SSD 8671 and SSD 7561 Consent Conditions Comments Register

WALSH BAY ARTS PRECINCT
LOADING DOCK - SWEPT PATH ASSESSMENT
8.8m MRV

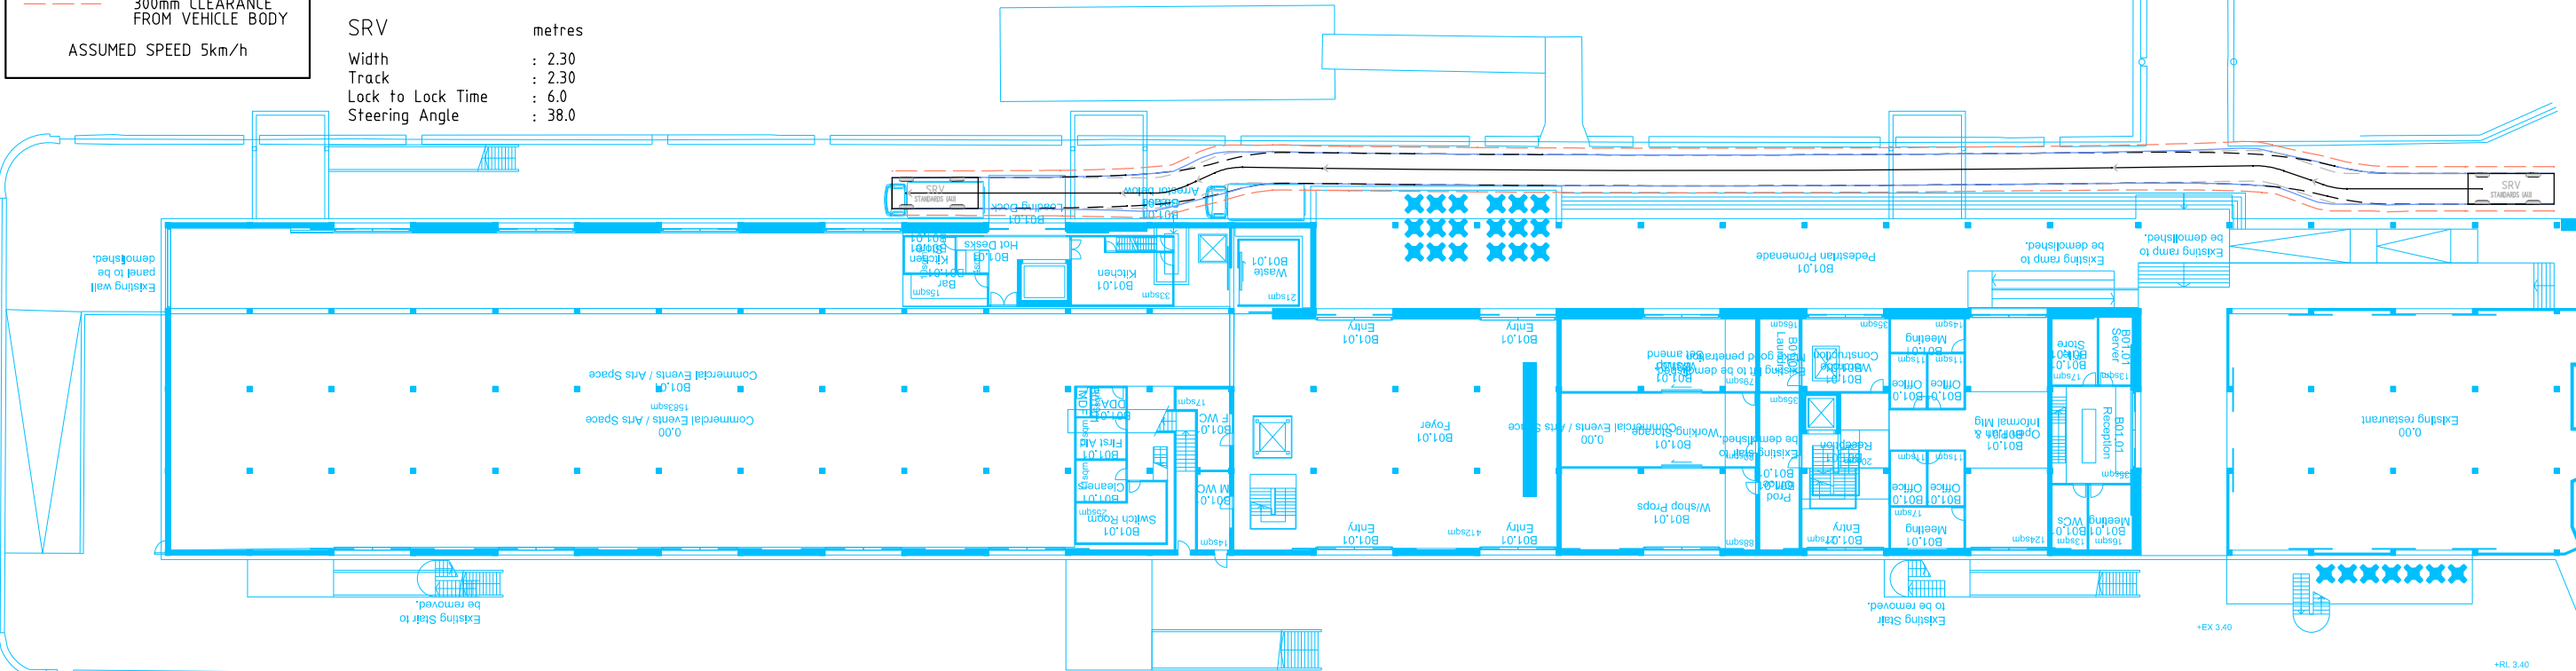
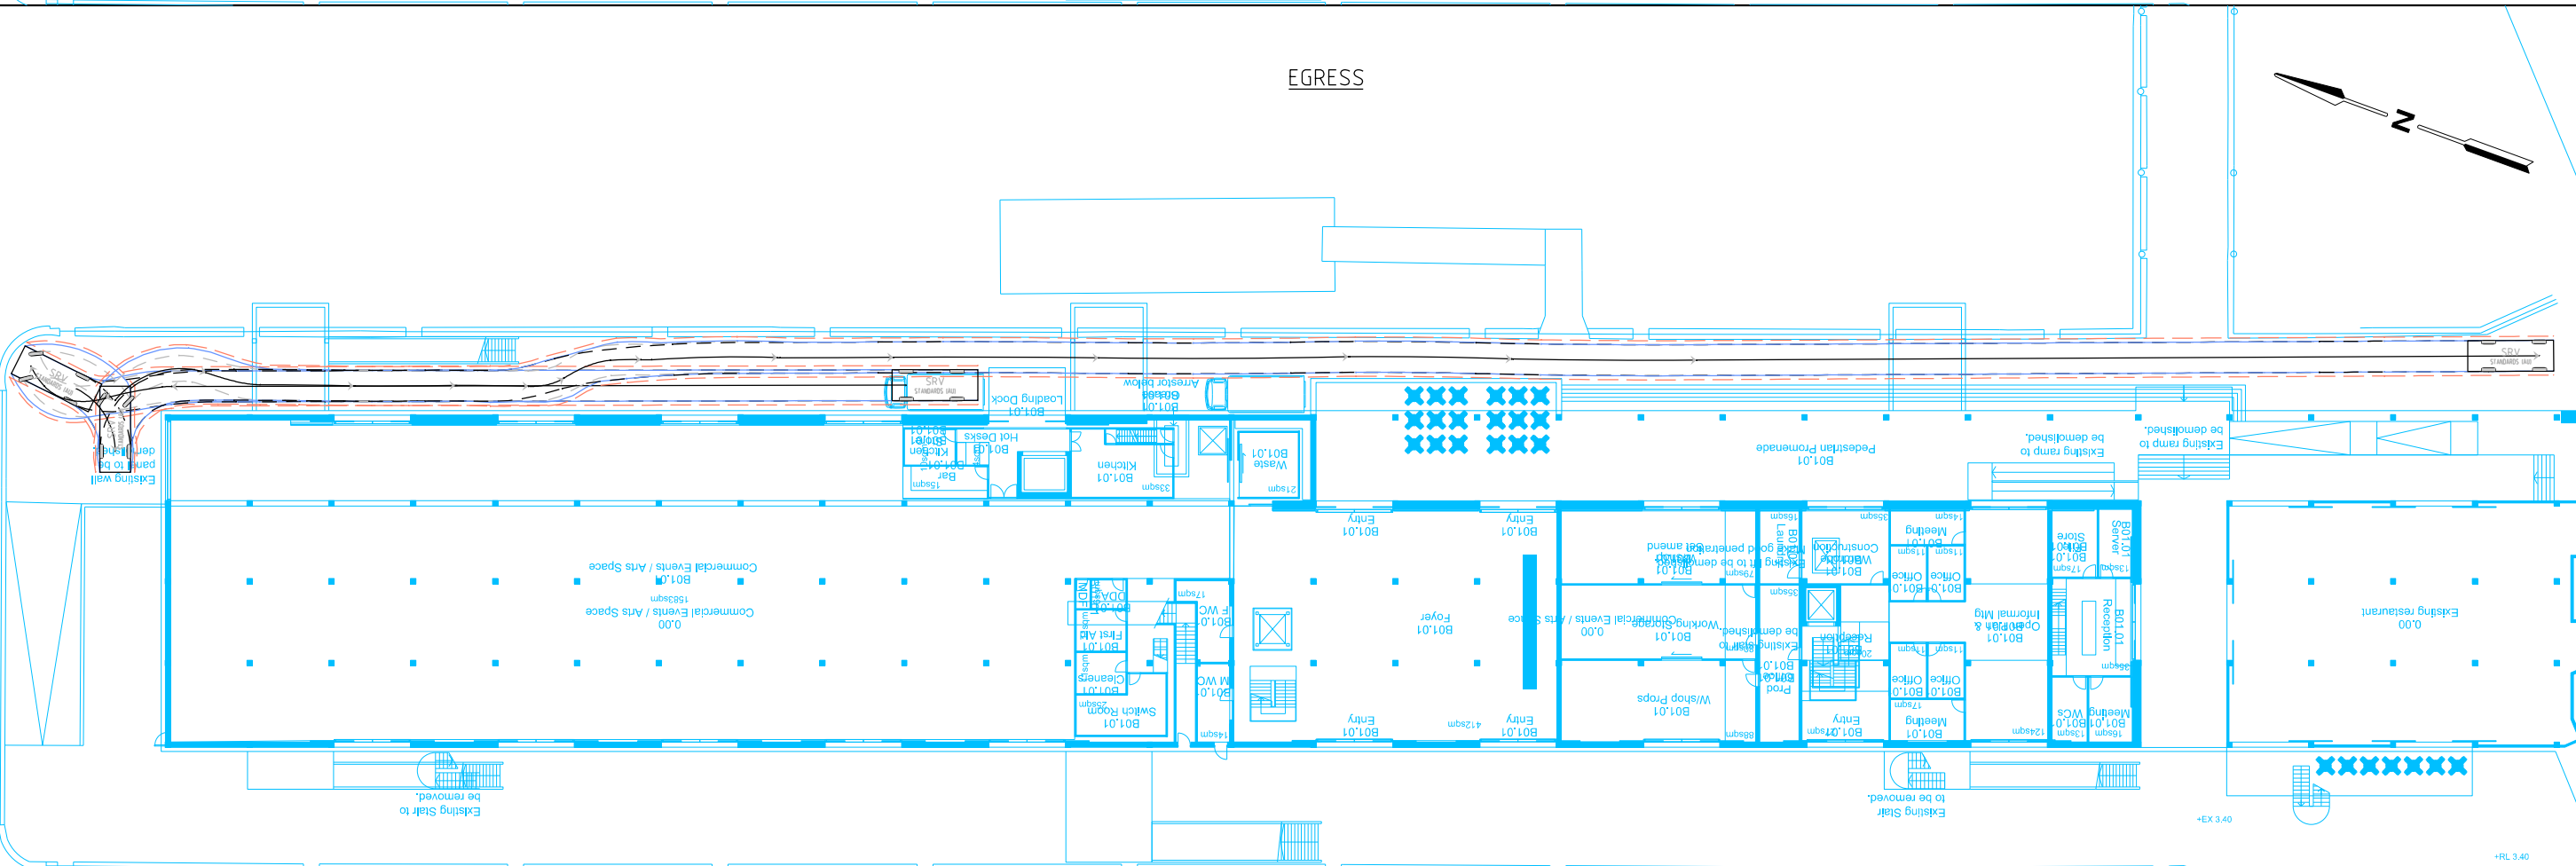
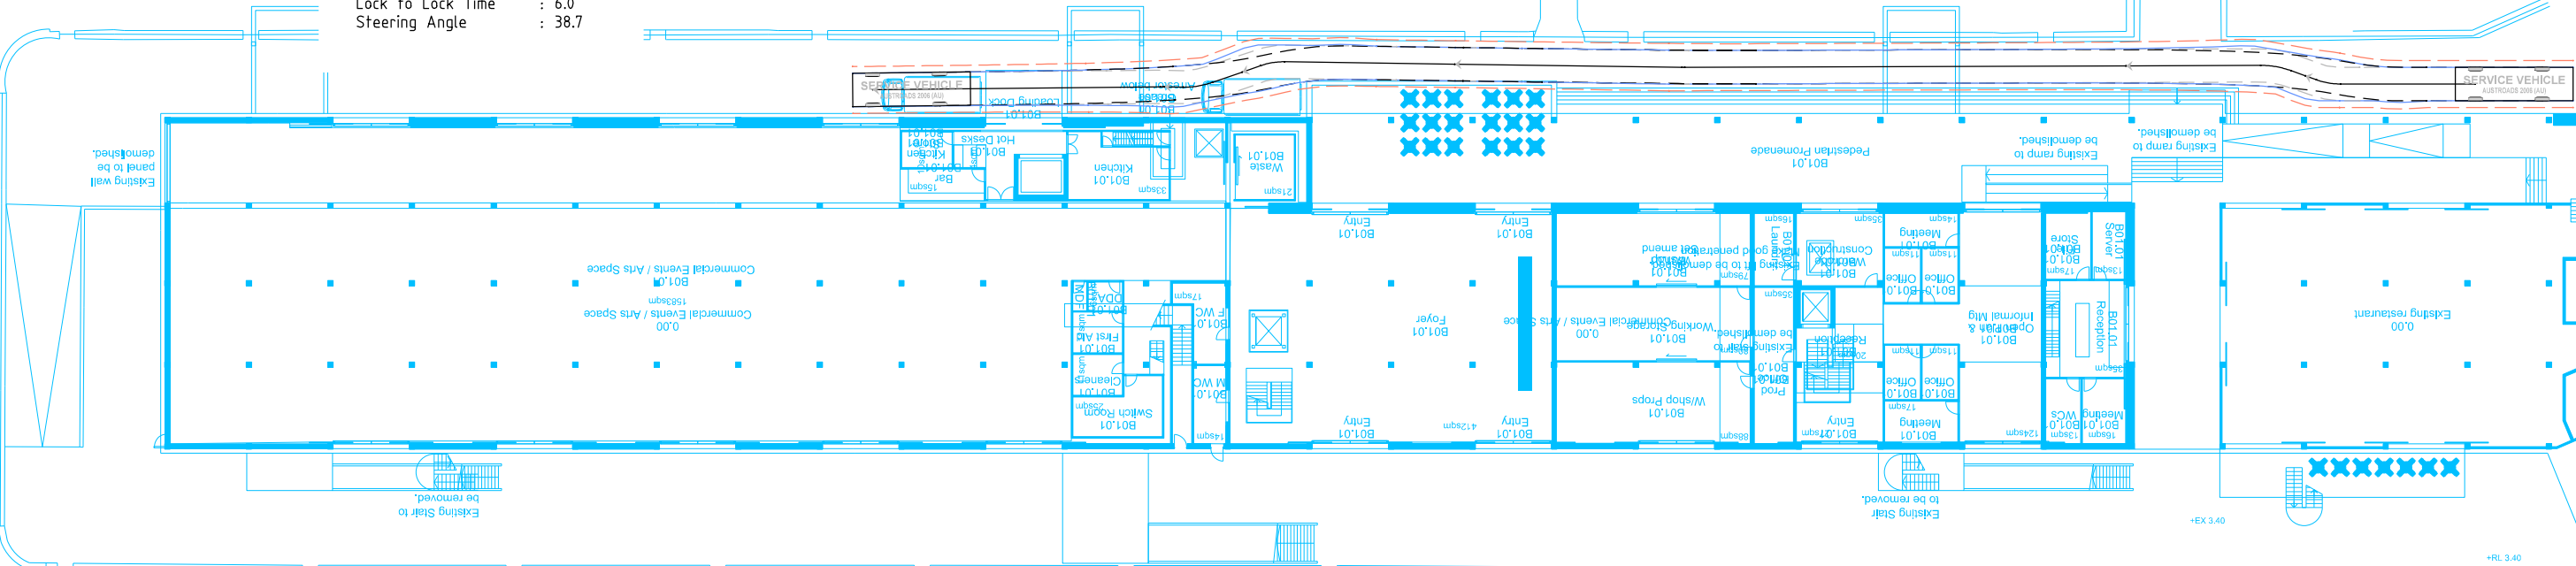
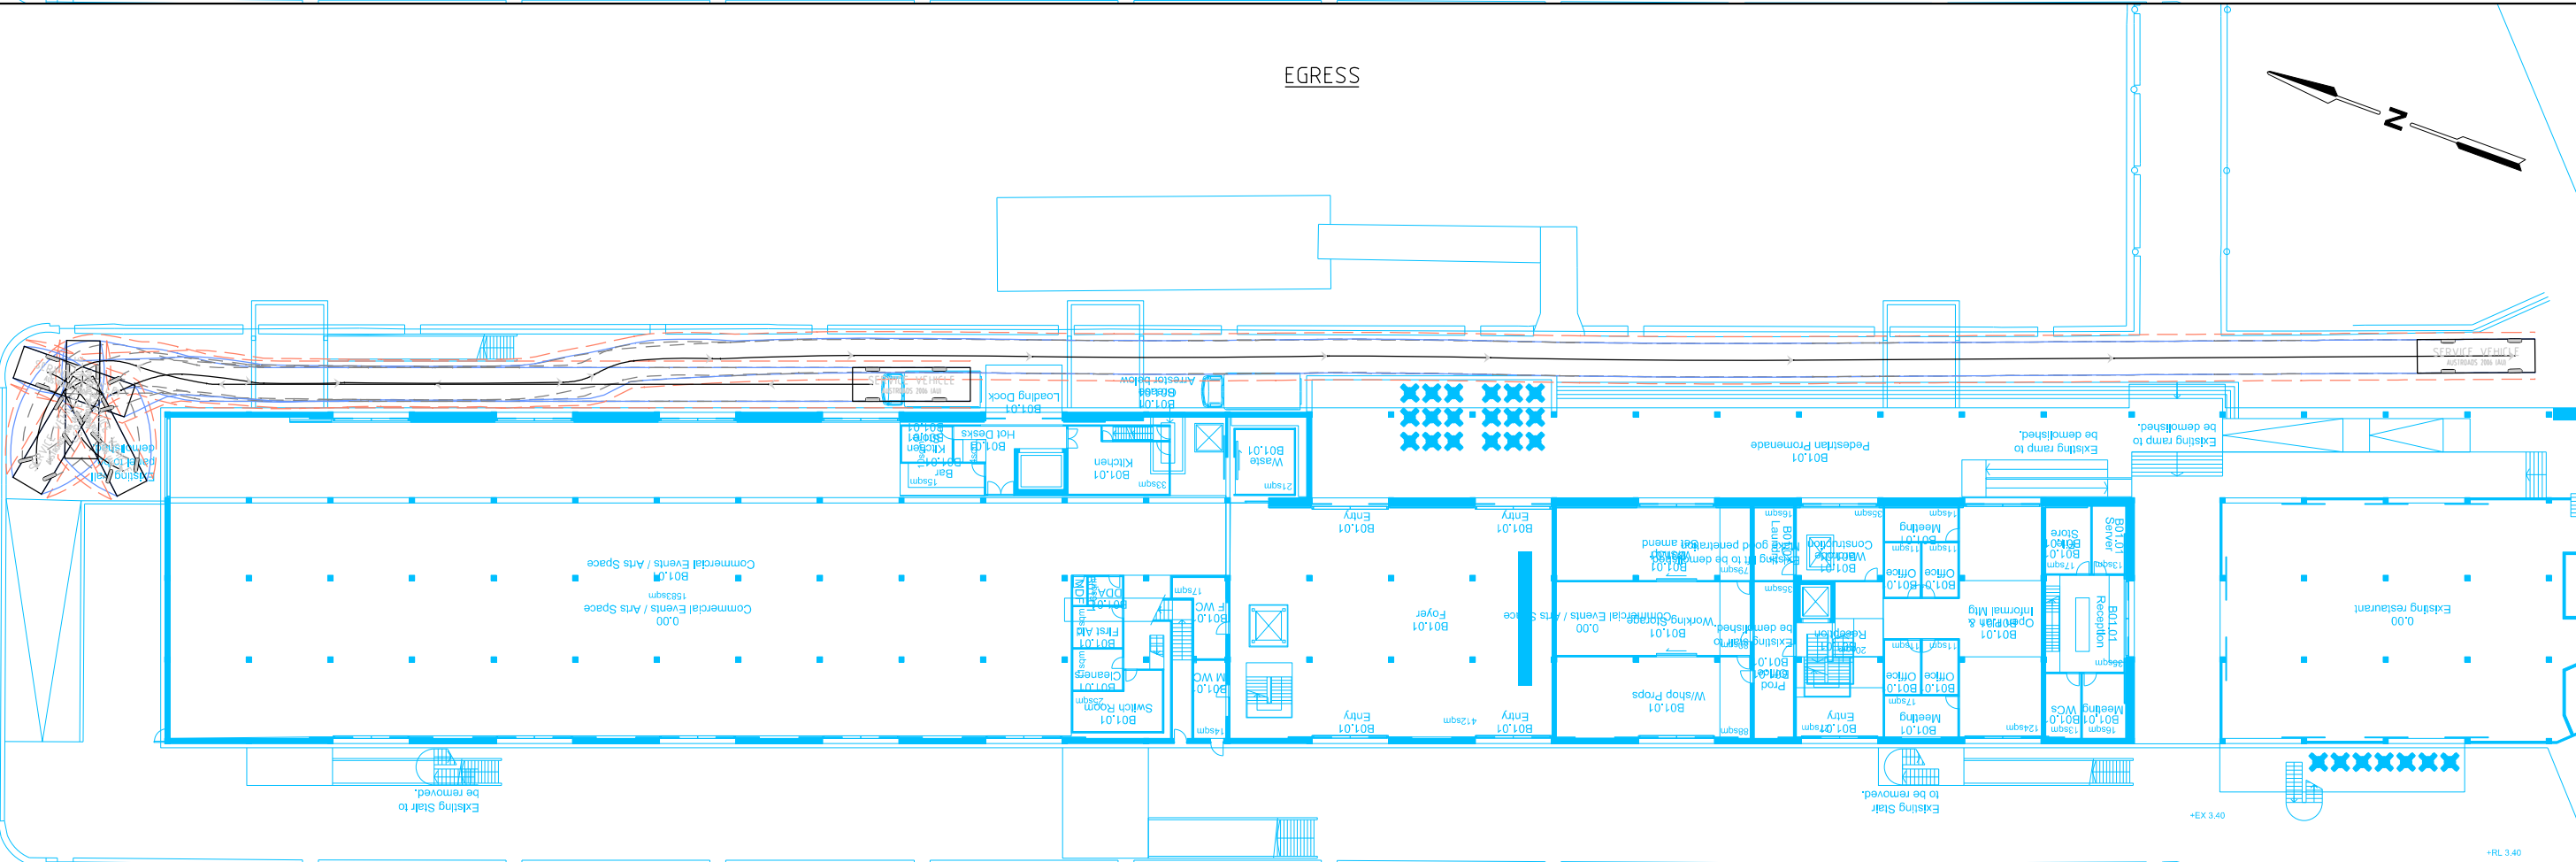
D9 - Service and Loading Dock Management Plan	City of Sydney	6	With regards to the attached swept path plans that you forwarded to me, the plan shows that the vehicle needs to use the full width of Pottinger Street to enter and exit. The plan does not take into consideration on-street parking east and west of the Pottinger Street Bridge	STC provided a response to CoS (dated 18 August 2020) noted that this issue is generally resolved by the parked car spaces north and south of the bridge are generally taken up by STC employees, an STC vehicle or vacant, therefore straight forward for STC to manage.
		D9 - Service and Loading Dock Management Plan	City of Sydney	7	Condition E5 c) of SSD 7561 requires measures to minimise the use of 8.8 metre medium rigid vehicles. Would you be able to advise how the Sydney Theatre Company proposes to do this.	<p>CoS comment is incorrect. Section E5 c) states that the LDMP shall address “c) measures to ensure service vehicles accessing the site larger than an 8.8m medium rigid vehicle are minimised.”</p> <p>The Operational Transport Plan submitted to the CoS for comment specifically addressed this item in section 6.4.1. The Sydney Theatre Company has confirmed that 19m articulated vehicles will only be used up to 12 times per year. They will be managed through the booking system, out of peak periods and planned well in advance. The proponent believes that 12 times a year for vehicles of this size represents a measure to minimise vehicles larger than 8.8m in accordance with the consent.</p>
